DOC25/849940-3

31 October 2025

EPA Follow-up Noise Advice – Botany Waste Transfer Facility – SSD 62855708

Figure 1: Acoustic site plan identifying the surrounding noise-sensitive receivers and relevant noise monitoring locations (source: SixMaps NSW)

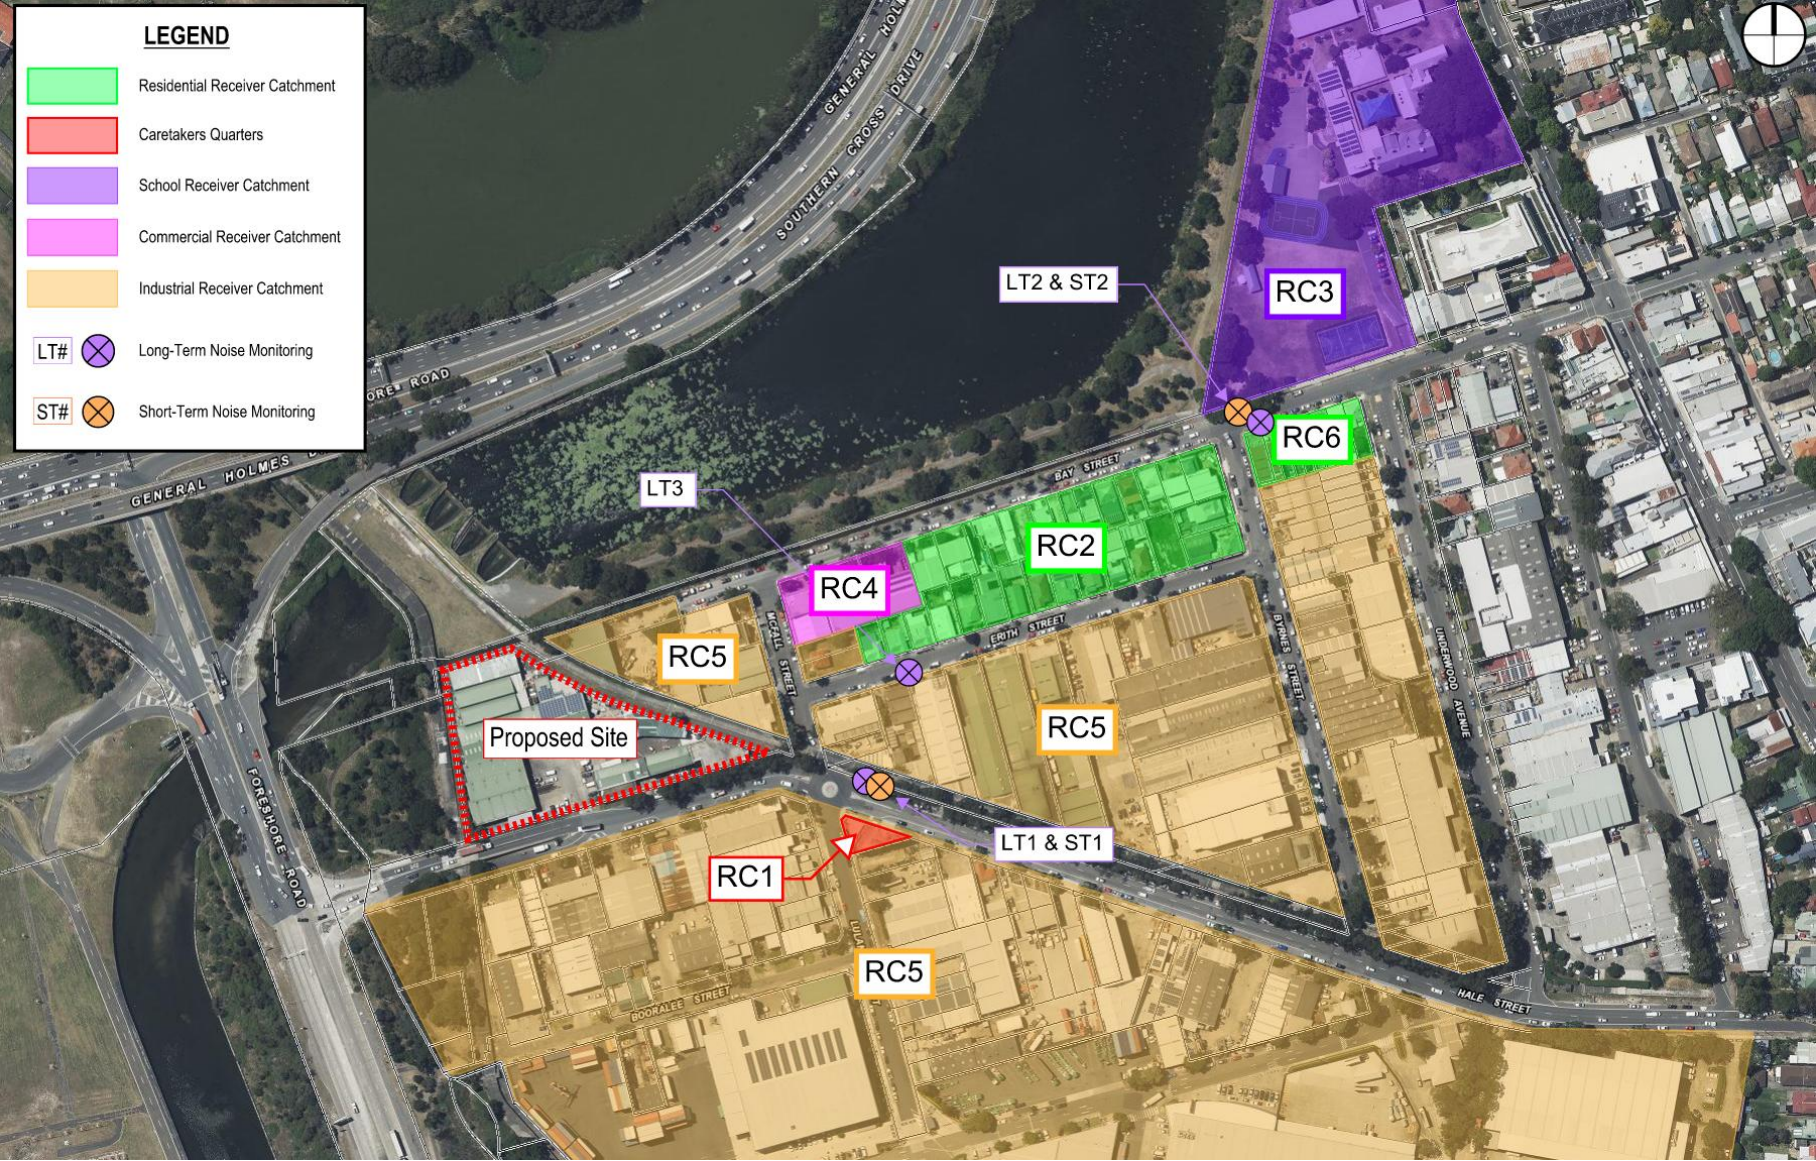
L6.1 Noise generated at the premises must not exceed the noise limits at the times and locations in the table below. The locations referred to in the table below are indicated by Figure 1 in the document - Noise and Vibration Impact Assessment, 2-4 Hale Street Botany – Building Waste Transfer Facility prepared by E Lab Consulting dated 1/9/2025, Project No.P00945, Revision 009.
